TO: All Staff
FROM: Public Works Plan Review Team
DATE: May 6, 2022
SUBJECT: VA-22-00002 Heidt

The Department of Public Works has reviewed the zoning variance application and recommends approval based on the following:

ATTACHMENT 2

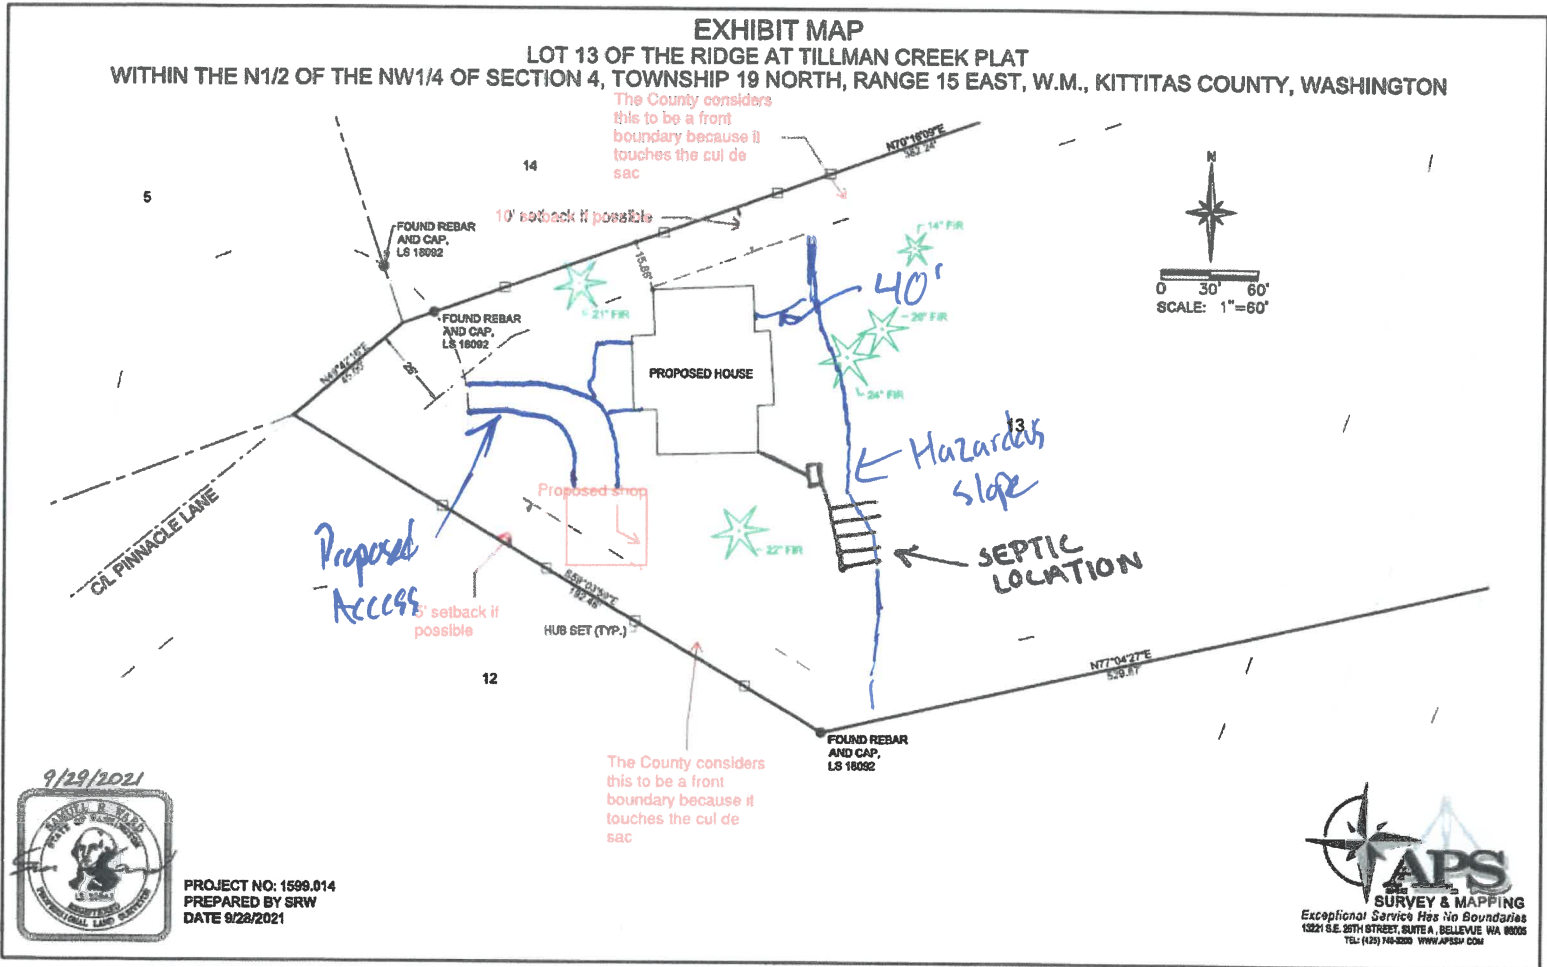
1. Distances on exhibit map do not match the project description. The map may show a 5 feet setback, but it is not identified on the map. The project identifies a 10 feet setback, but the map identifies a 15.96' feet setback.

2. A five feet setback poses constructability problems without trespassing into the neighboring parcel. Public Works believes that a written statement from the neighboring landowner approving a short-term construction easement would suffice.

3. Building footings, grading, overhangs and swinging doors cannot trespass into the neighboring parcel.
4. Given the tight tolerances required, having the boundary line staked by a land surveyor prior to construction should be required.

5. All elements of map should meet the requirements of WAC:332-130-145
6. Snow storage in regard to the shop may land on neighboring property, suggest an agreement with neighboring property for snow removal and/or storage.
